## WEST SUSSEX COUNTY COUNCIL CONSULTATION

| <b>LOCATION:</b>                | 209 Pagham Road Bognor Regis PO21 3QD                                                                                                          |
| <b>SUBJECT:</b>                 | P/98/20/DOC<br><br>Approval of details reserved by condition imposed under P/111/19/PL relating to condition 8-electric charging for vehicles. |

| CLIENT<br>McDonald Homes South Ltd                    |      | DRAWING TITLE<br>Land Registry Plan<br>First Floor Unit |           |

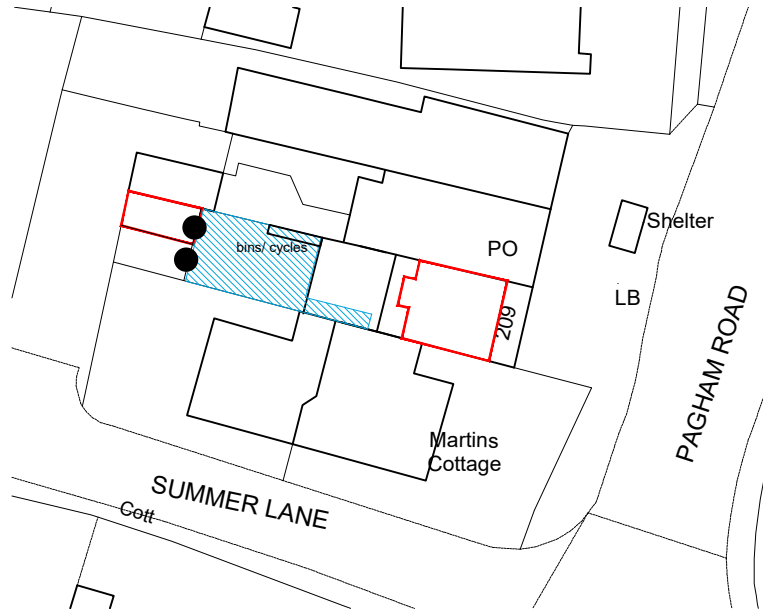
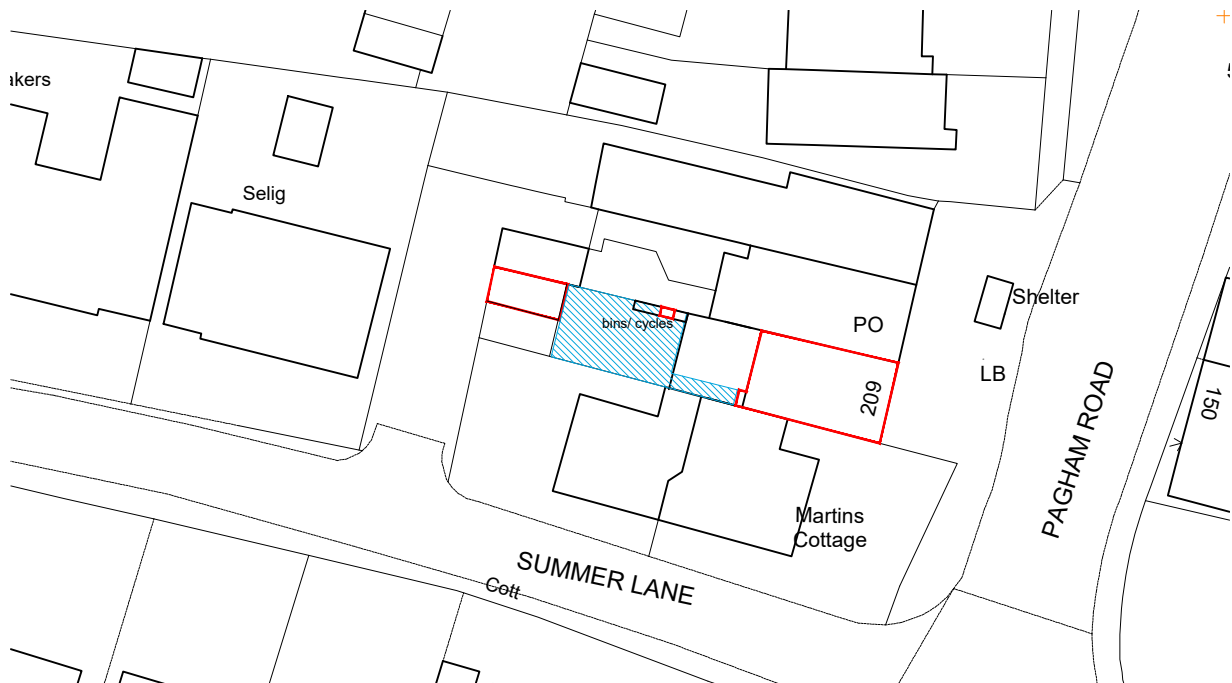
As the LHA did not advise the above condition, these comments represent advice only. The applicant has provided details of the type of EV charging facility which will be installed on site. This appears to comply with the above condition. However, it is noted that no plan has been provided setting out the location or proposed provision of the EV charging space(s). The LHA note that Condition 6 secures the following: *No part of the development shall be first occupied until the car parking spaces have been constructed in accordance with the approved plans, and one of these car parking spaces shall be marked out for Electric Vehicles only.* As such, should the LPA consider it acceptable, details pertaining to the provision and location of the EV charging space can be dealt with under Condition 6.

In conclusion, as stated above, if the LPA are minded to accept details of EV parking provision and location under Condition 6, the LHA would expect that Condition 8 can be discharged.
